Application for Planning Permission for Works or Extension to a Dwelling

Development: Demolition and rebuilding of garden building.
Location: Little Thatch 93 Middleton Road Middleton-On-Sea PO22 6DW

I regret that I am unable to accept your documents as a valid application until the following item(s) have been received or resolved :-

LOCATION AND BLOCK PLANS

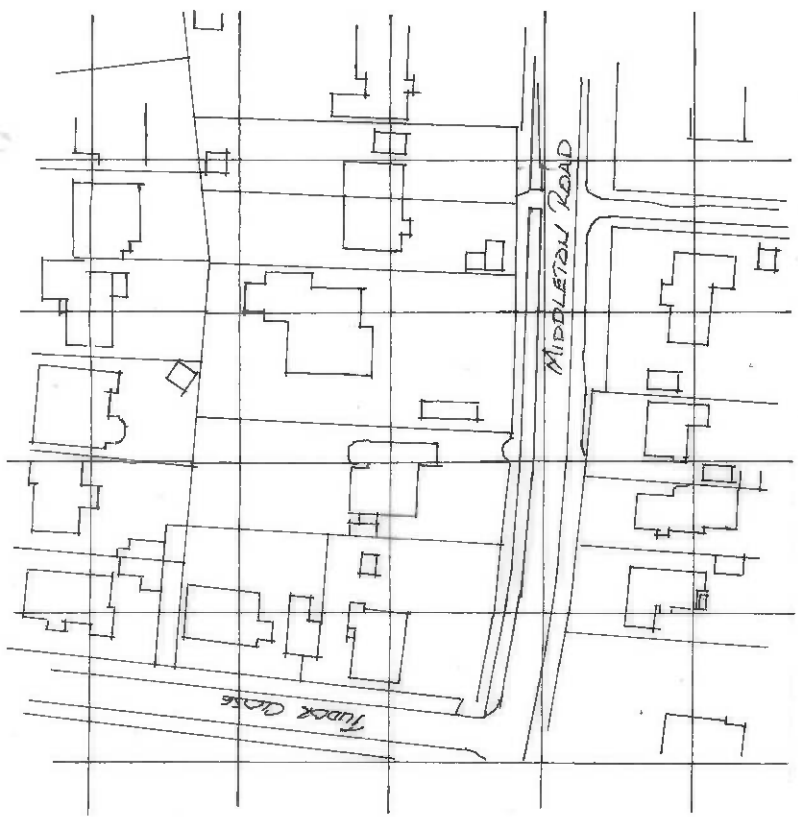
Location Plan Insufficient

The location plan requires a solid red outline around the site boundary, please review and amend. Further details of what must be included on the plan can be found in the Validation Requirements List.

Block Plan

You are required to have dimensions from the proposed extension(s) to all site boundaries. Please amend
